Farzana Tabasum  
Kirklees Metropolitan Borough Council  
Development Management

**Our ref:** RA/2022/145211/01-L01  
**Your ref:** 2022/93766

**Date:** 14 December 2022

**ERECTION OF THREE INDUSTRIAL SHEDS ON EXISTING INDUSTRIAL SITE.  
SYNGENTA LTD, LEEDS ROAD, HUDDERSFIELD, HD2 1FF**

Figure 4: Flood Map for Planning (Rivers and Sea)

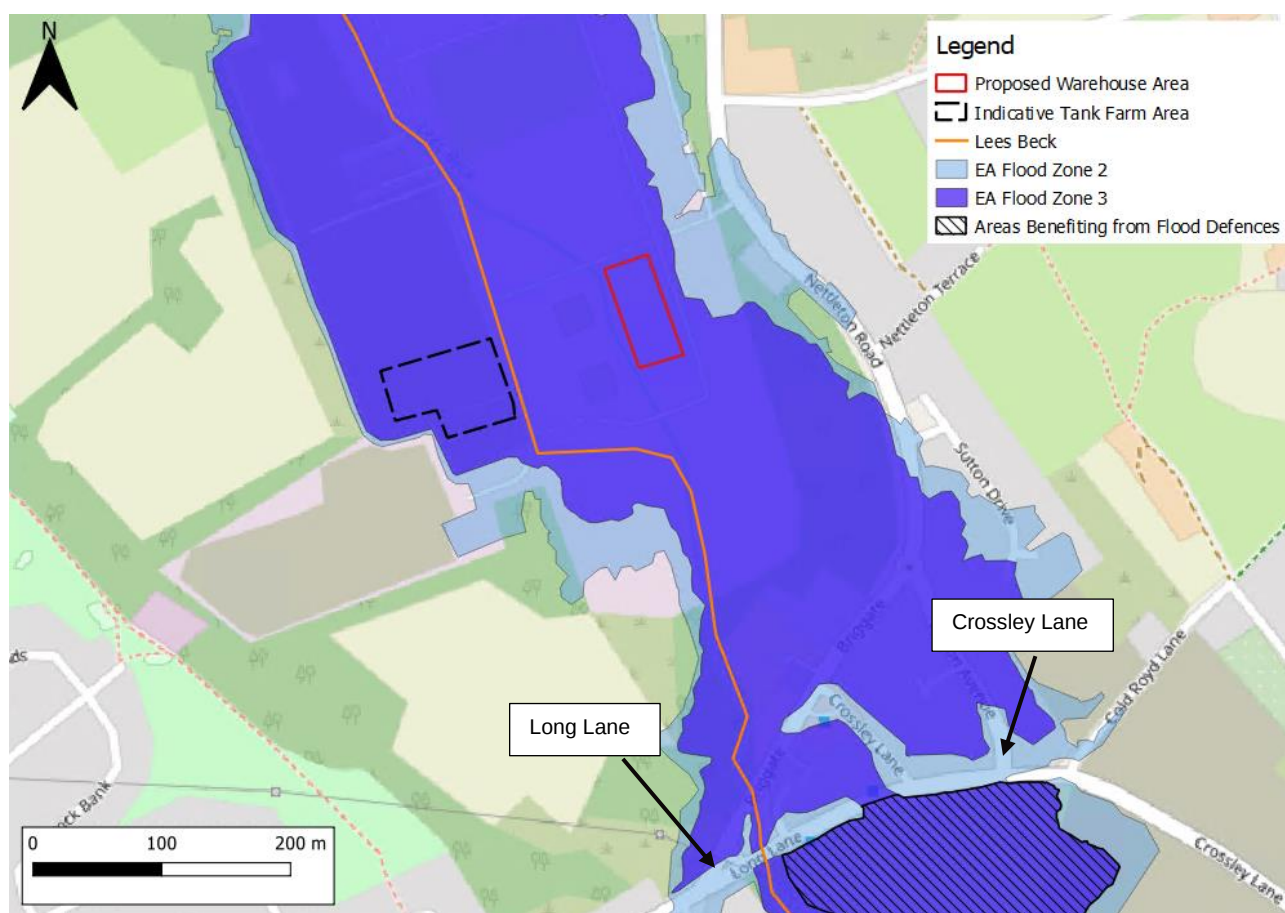
Our Flood Map for Planning shows the site lies within Flood Zone 3, with a high probability of flooding from rivers. The application is for industrial buildings, which are considered to be a 'less vulnerable' land use in [Annex 3](#) of the National Planning Policy Framework. It is therefore necessary for the application to pass the Sequential Test and to be supported by a site-specific flood risk assessment (FRA), which can demonstrate that the 'development will be safe for its lifetime taking account of the vulnerability of its users, without increasing flood risk elsewhere, and, where possible, will reduce flood risk overall'.
